REVIEW COMMENTS

Project:		MDS Artiste TIA			PDE:	
Review:		Draft Dated 2/05/2025			Reviewers:	
Date:		5/1/2025			Richard Meadows, Bernalillo County. Curtis Cherne, PE for CABQ

Figure 1: Site Plan

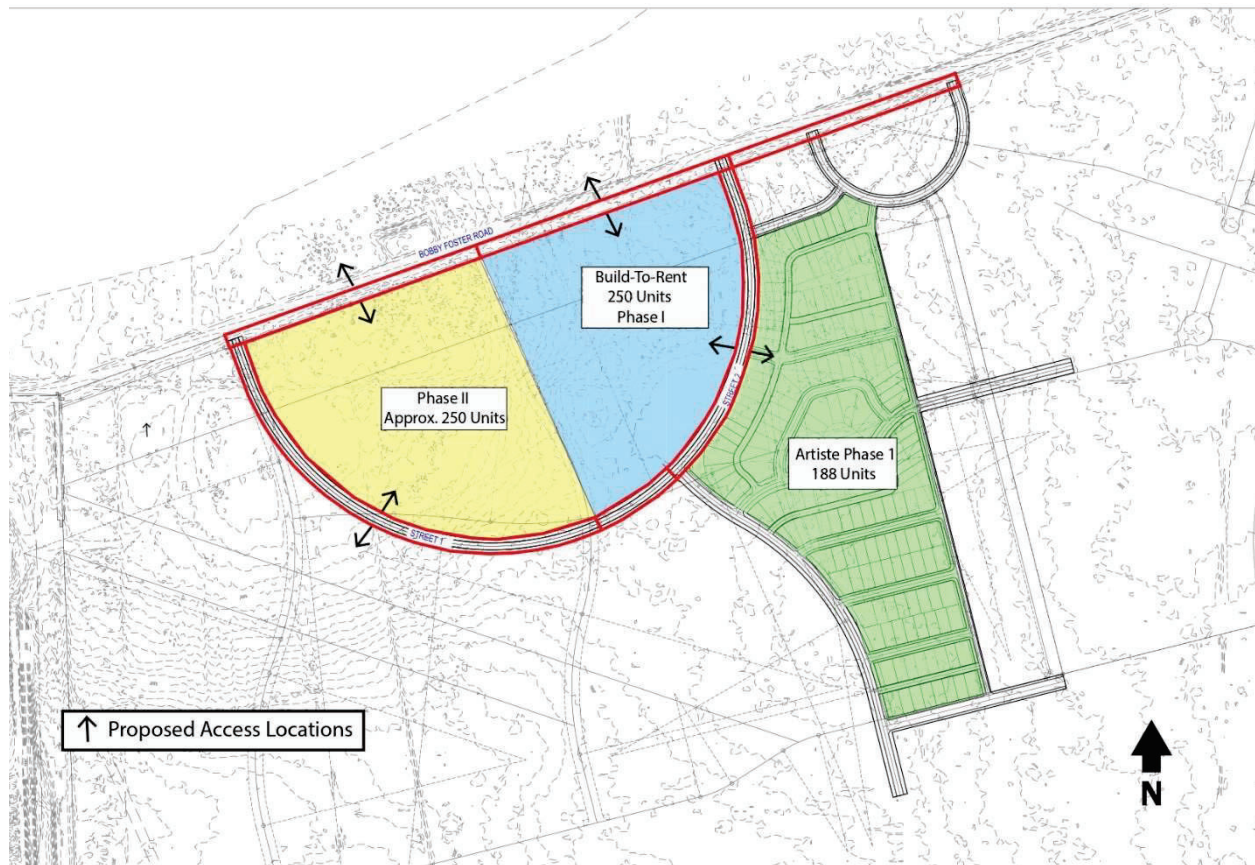
6	19	Informational Purposes	The use of the DPM on this page is not correct. On the site plan please provide the local road spacing. Based on the DPM, this spacing is required to be no more than 600'. This page describes access analysis on a 40-mph minor collector based on Table 7.4.34 Minimum Distance Between Commercial Site Access and Intersection. There are two errors: this is not the intended use of this table and in the Long Range Roadway System, Bobby Foster is planned to be a future community principle arterial. The appropriate table is Table 7.4.41 Characteristics by Location (page 7-46). Please see "Block Length" column for local road spacing and "Major Road Spacing" for collector road spacing. Although portions of MDS is within an activity center and employment center, this area is not. The applicable row is "Other Areas/Local Streets	County of Bernalillo	Agree	The text in the Site Access Analysis and Justification section of the report has been updated to refer to the correct DPM table.

12			Another Minor Collector is due 1320 feet west of the one discussed above.	CABQ	No Action	See Streets 1 & 2 on site plan. Per Ron Brown: the roads support the original connectivity plan. See pending bulk land plat.
13			The collector streets will connect to Mesa Del Sol Blvd to the south.	CABQ	No Action	See Streets 1 & 2 on site plan. Per Ron Brown: the roads support the original connectivity plan. See pending bulk land plat.
14			Please see the MRCOG Long Range Roadway System and the DPM for the street network	CABQ	No Action	See notes above.
15			Add a discussion and figure to the Study and state how this development supports the collector street network.	CABQ	Agree	A short discussion has been added to Page 3 discussing the coordination with the latest MDS Community Master Plan.
16			The proposed semi-circular road appears to be in the approximate location where the major collector is to be located.	CABQ	Agree	Street 1 and Street 2 labeled on the site plan have been updated to be named "Collector A" and "Collector B".
